Recommendation Report for Planning Permission for Works or Extension to a Dwelling

REF NO: Y/26/26/HH

LOCATION: Frogs Lodge
Drove Lane
Yapton
BN18 0EB

PROPOSAL: Proposed front and side extensions, loft conversion to provide three additional bedrooms, increase in the existing roof ridge height by 2.4 metres and formation of a recessed balcony to the south west elevation.

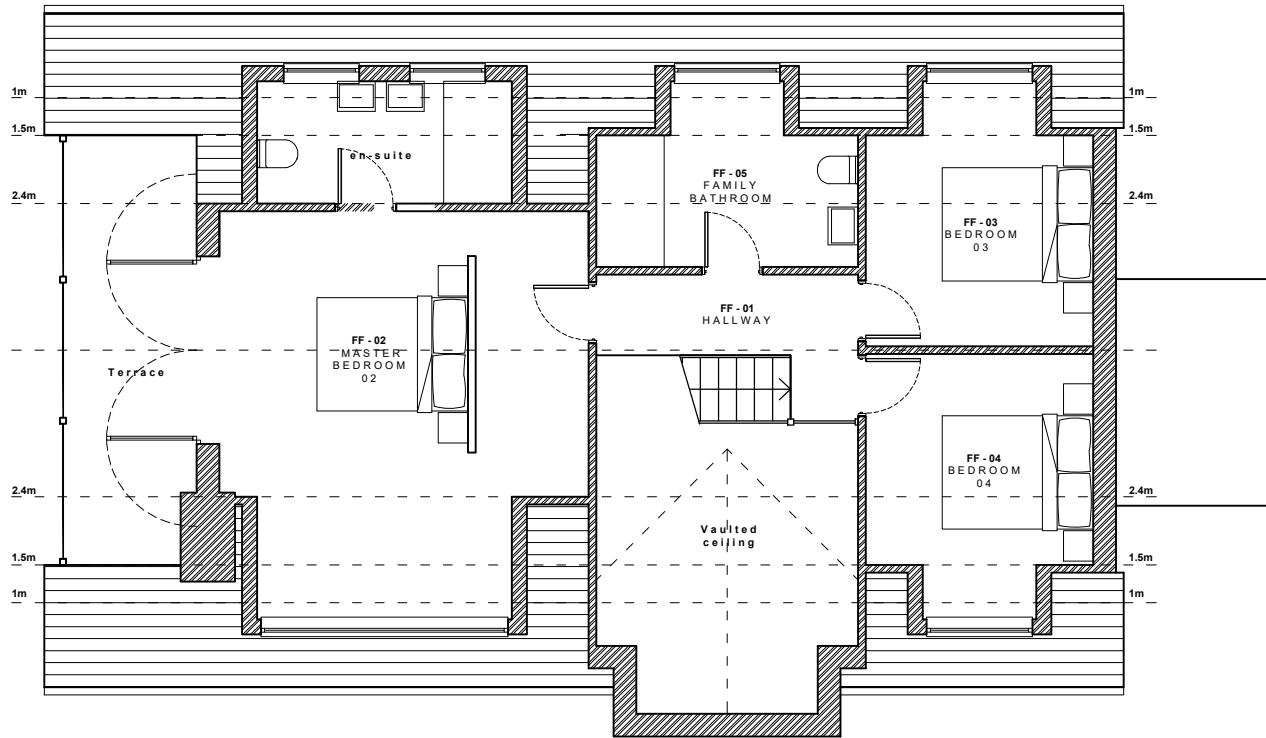
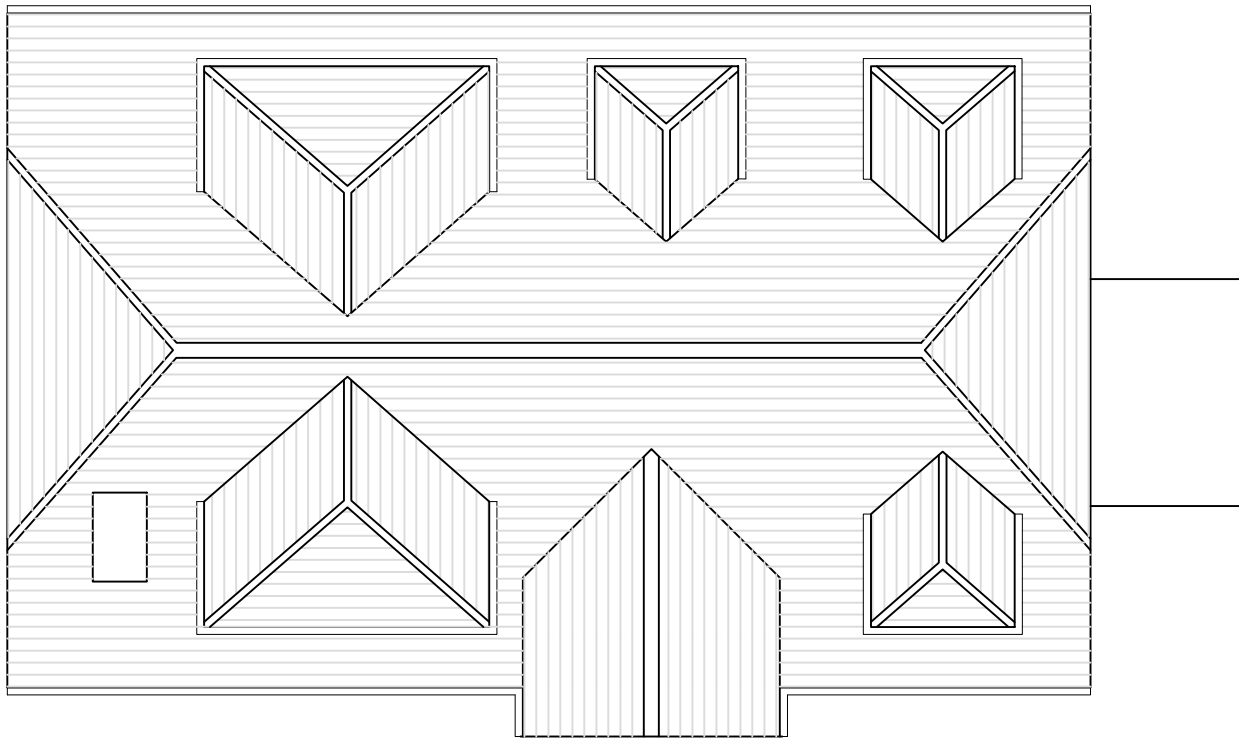
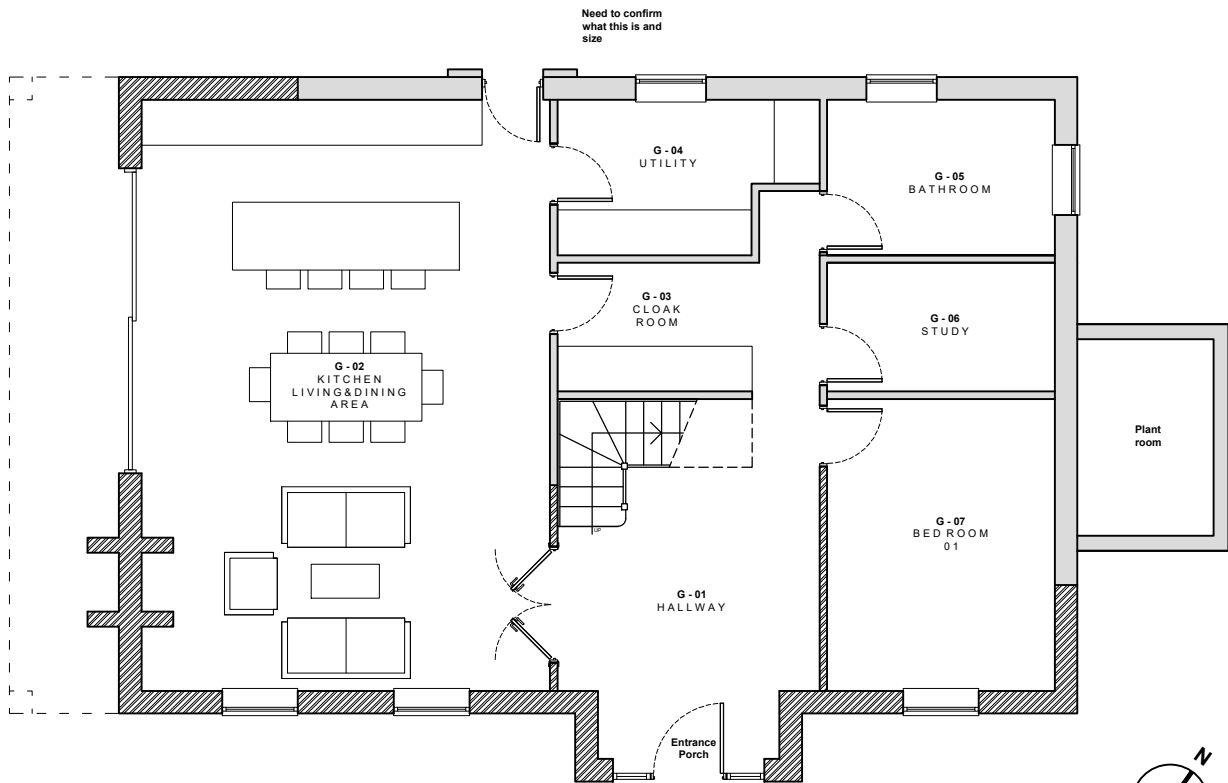
The front extension would measure approximately 1.7m in depth and would adjoin the proposed side extension, creating a wraparound addition with an overall width of approximately 12.7m. The roof would form part of the wider roof alterations and would reach a maximum height of approximately 7.6m, finished in red/brown clay roof tiles. The proposed external materials would include stonework, differing from the predominantly rendered finish of the existing dwelling. Given the rural character of the site and the use of similar materials on comparable rural properties, the proposed stonework would be acceptable in this context. The front elevation would incorporate three sash windows reflecting the style and proportions of the existing fenestration.

The proposed side extension would measure approximately 2.4m in width and 8.4m in depth. As with the front extension, the roof would form part of the wider roof alterations and would incorporate a hipped roof form. The external finish would include stonework to match the front extension, which would be acceptable given the rural setting of the site. Large sliding glazed doors are proposed within the south-western elevation, whilst the remaining ground floor openings would remain largely unchanged.

The side extension would not be set back from the principal elevation and would not be set down from the existing ridge height, contrary to the guidance contained within the ADG, which advises that side extensions should be set back from the front elevation and have a ridge height at least 0.5m lower than the host dwelling. However, the proposed loft conversion would be built above the side extension, resulting in a form of development that would not appear fully subservient to the original dwelling and would increase its overall bulk and massing.

The proposal would also involve significant roof alterations, raising the ridge height from approximately 5.2m to approximately 7.6m. The resulting roof form would comprise a hipped roof with cross gables and include five gable dormers. A recessed balcony is proposed within the south-western elevation, accessed via glazed doors at first-floor level. The balcony would be supported by four columns, with the overhang creating a covered patio area serving the ground floor side extension. In addition, the existing chimney stack on the north-eastern elevation would be removed, leaving a single chimney on the south-western elevation.

The loft conversion would introduce additional fenestration, including two dormer windows on the south-eastern elevation, three dormer windows on the north-western elevation, and glazed doors serving the proposed balcony on the south-western elevation. Due to the isolated nature of the site and the absence
